Project Special Provisions
(Version 06.5)
Signals and Intelligent Transportation Systems

1. 2006 STANDARD SPECIFICATIONS FOR ROADS & STRUCTURES

The 2006 Standard Specifications are revised as follows:

ENGLISH DETAIL DRAWING FOR
INDUCTIVE DETECTION LOOPS

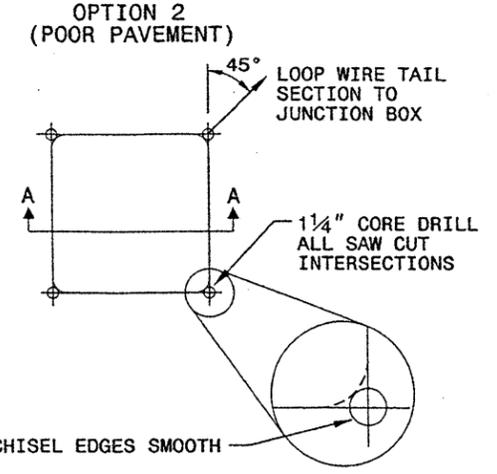
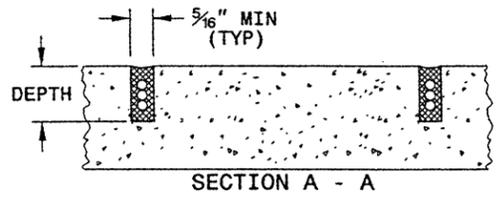
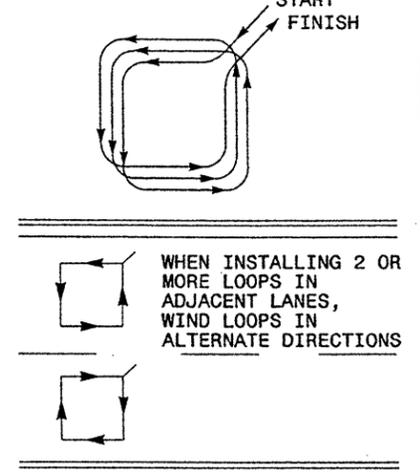
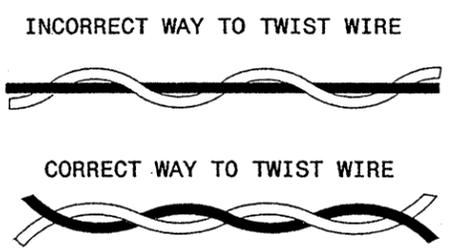
“Twist loop conductor pairs a minimum of 5 turns per foot from where conductors leave saw slot to junction box.
